East Anglia ONE North and East Anglia TWO Offshore Windfarms

Applicants' Responses to Examining Authority's Written Questions 2

Volume 6 – 2.10 Landscape and Visual Impact

**Figure: 29.37f**  
**Viewpoint 5: Public Right of Way, near Moor Farm**

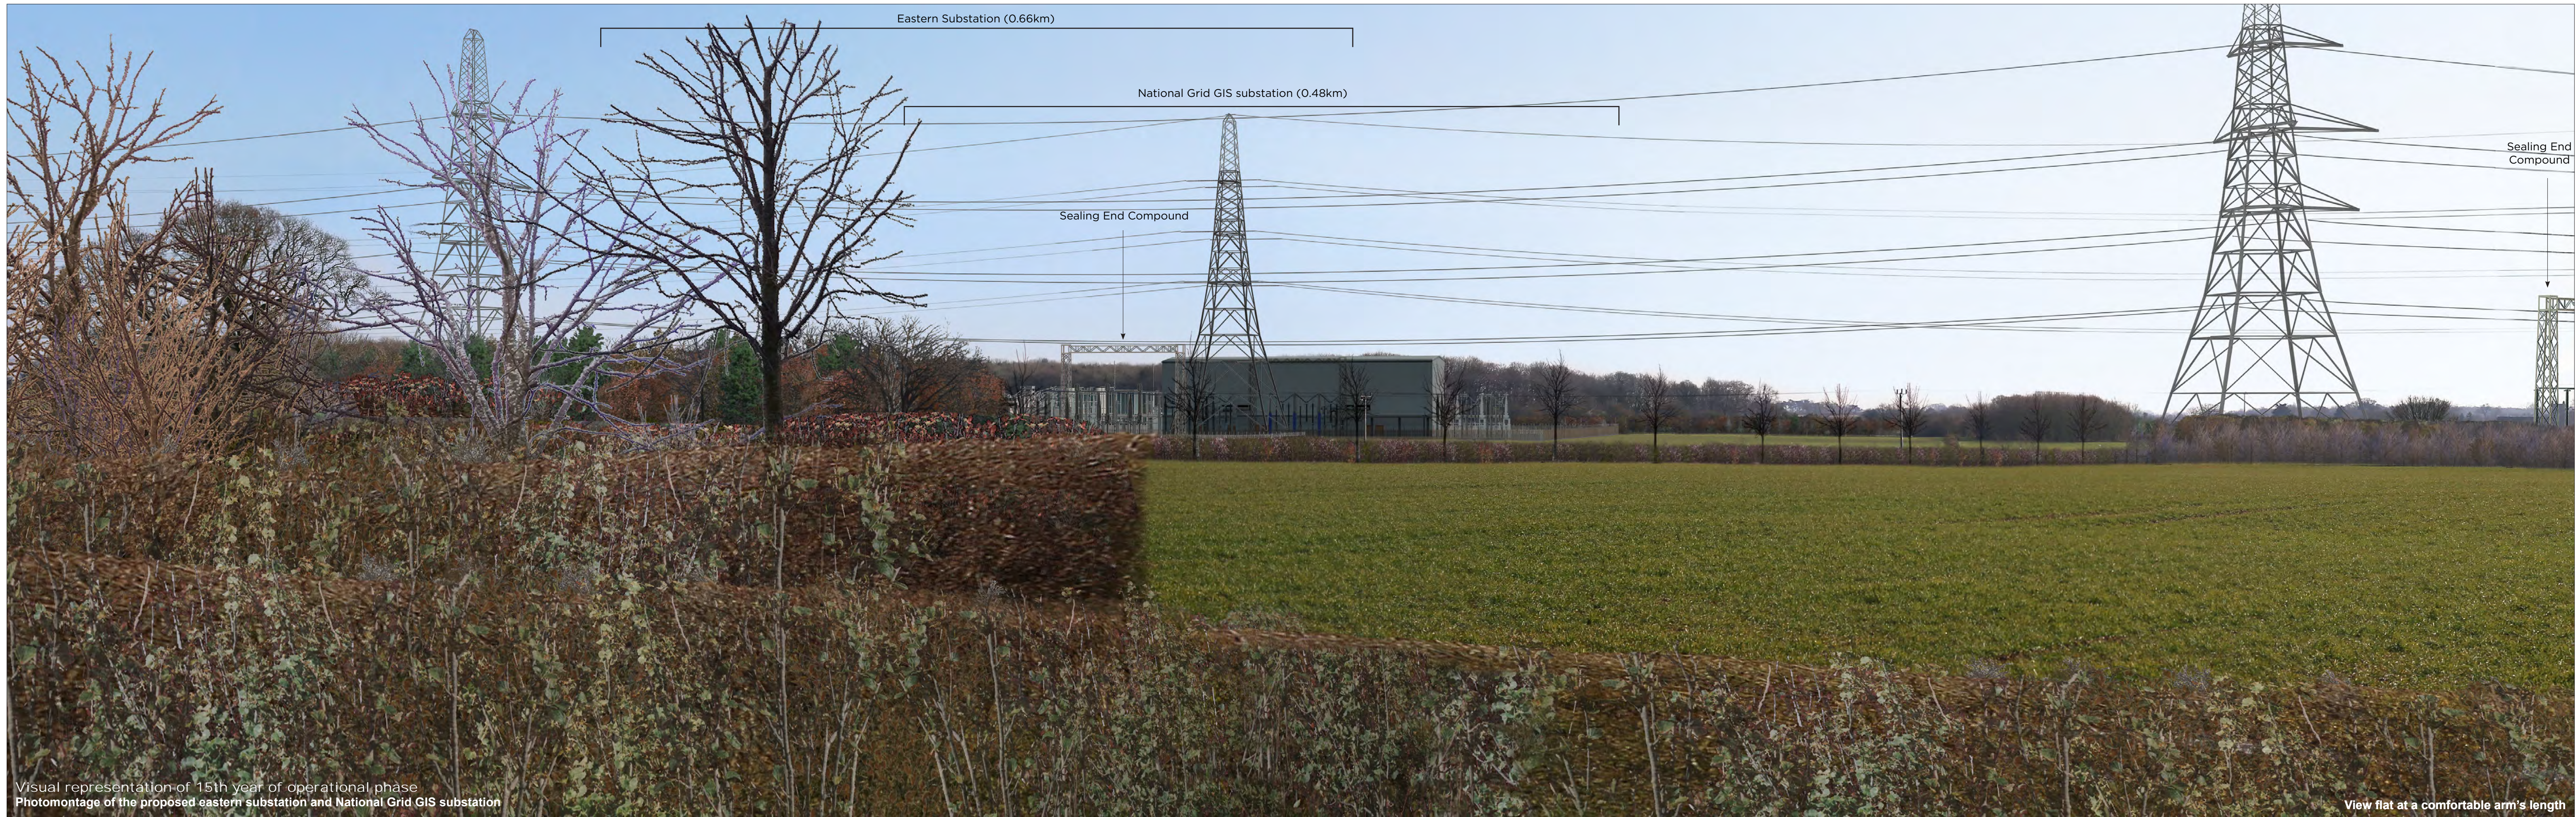
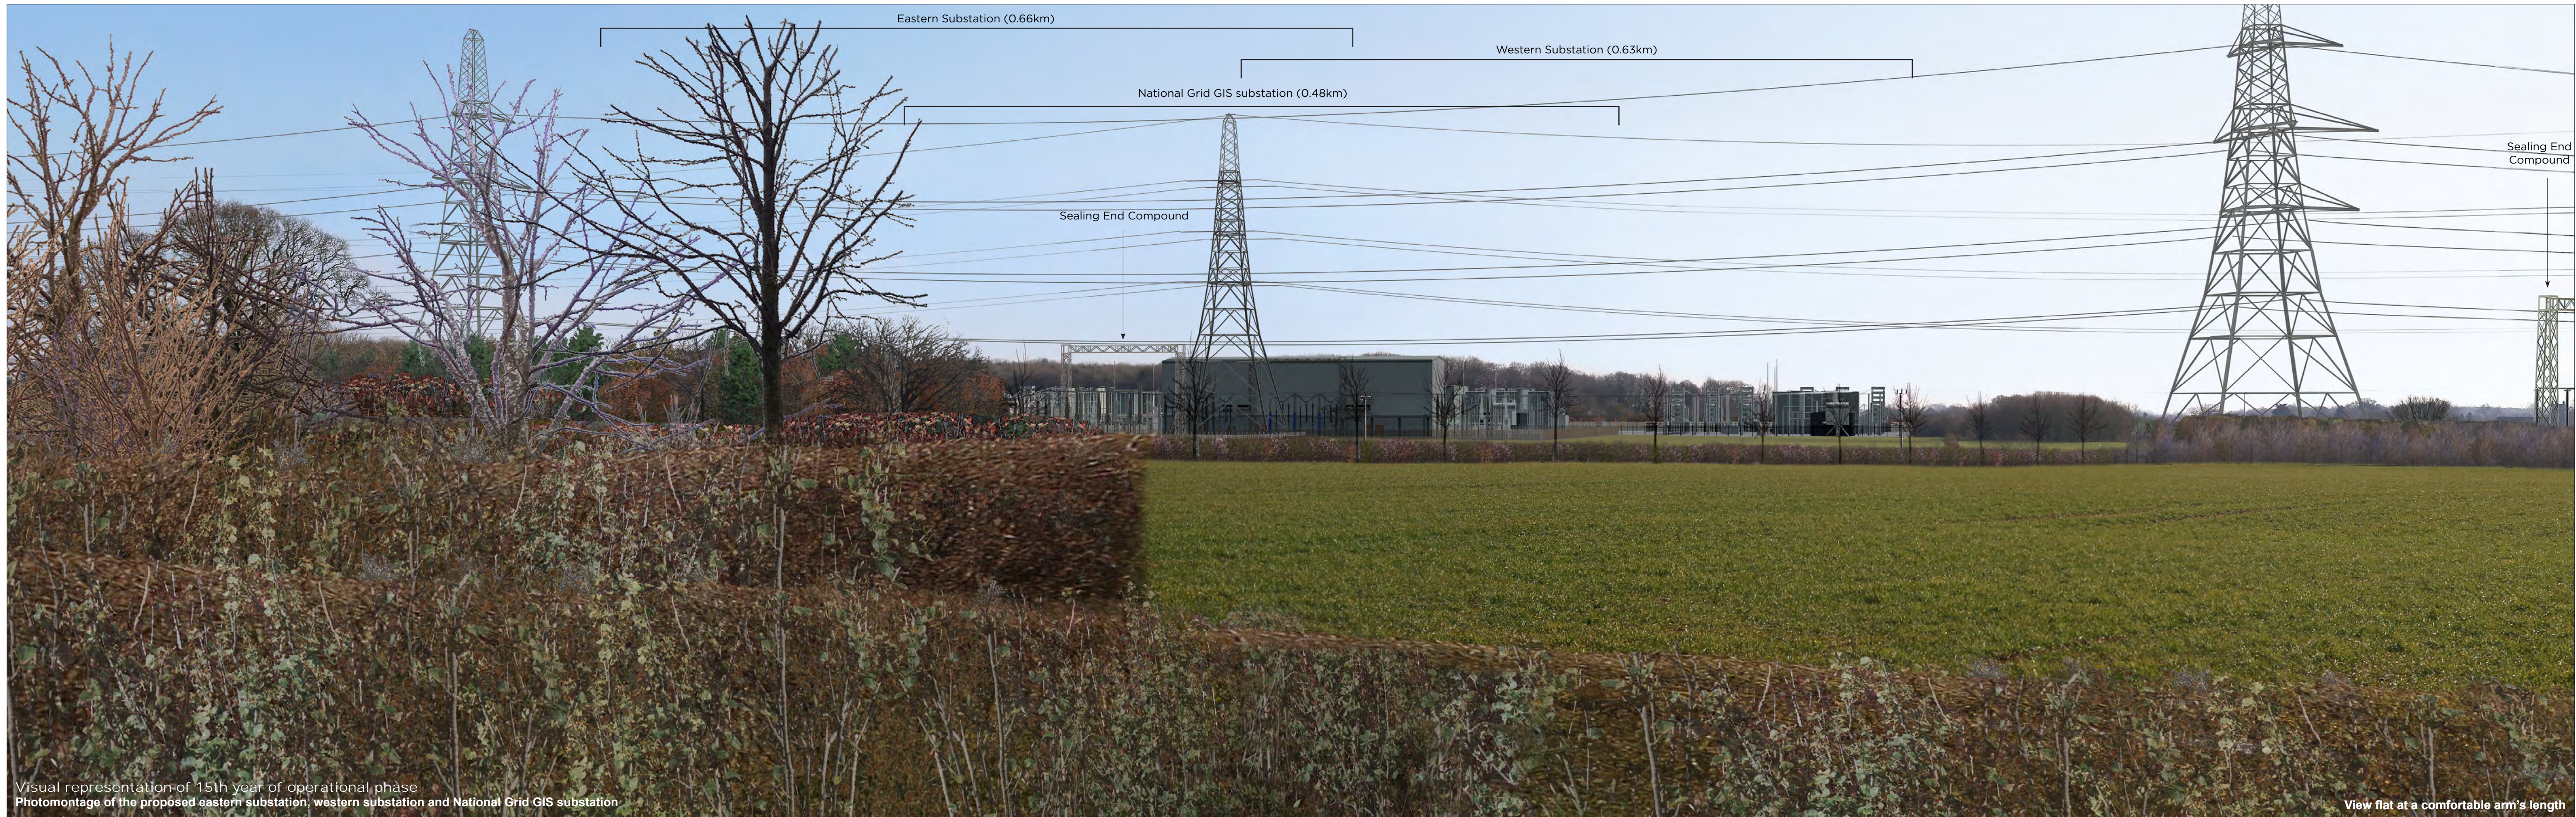
| ExA. Question Ref. | Question addressed to | ExA. Question | Applicants' Response |
|--------------------|-----------------------|---|---|
| 2.10.7 | Applicants, IPs | <p>Proposed sealing-end compounds</p> <p>[REP4-036] EA1N Landscape and Visual Impact Assessment Addendum - Appendix 5 - Viewpoint 5 PRoW near Moor Farm (Figure 29.17 Update) shows at year 15 that the western most sealing end compound, in particular, is clearly visible from the viewpoint despite the additional planting described in paragraphs 45, 100 and 110 of the OLEMS [REP3-030] to provide additional screening.</p> <p>Is the additional planting successful in providing additional screening and, if not, are there further</p> | <p>The Applicants consider that the additional proposed planting described in the OLEMS (an updated version has been submitted at Deadline 6, document reference 8.7) is successful in screening the lower to mid-sections of the cable sealing end compound identified. Due to its proximity to the cable sealing end compounds and overhead electrical lines (which requires electrical safety clearance distances), this planting was proposed as W2 native edge woodland consisting of smaller native trees and shrubs, assumed to have heights between 2-5m.</p> <p>The Applicants applied a precautionary principle with respect to potential planting of taller tree species around the cable sealing end compounds, however the Applicants note potential to plant faster</p> |

| ExA. Question Ref. | Question addressed to | ExA. Question | Applicants' Response |
|--------------------|-----------------------|--|---|
| | | measures that can be taken to more adequately screen the sealing end compounds? | growing / taller tree species (subject to agreement of the relevant planning authority) to provide a further screening, such as W1 or W2 species mixes, subject to the final design of the cable sealing end compounds and detailed consideration of the potential constraints of taller species near to the overhead line/sealing end compounds to be undertaken as part of the LMP, with the potential to provide a greater degree of screening of this cable sealing end compound. |
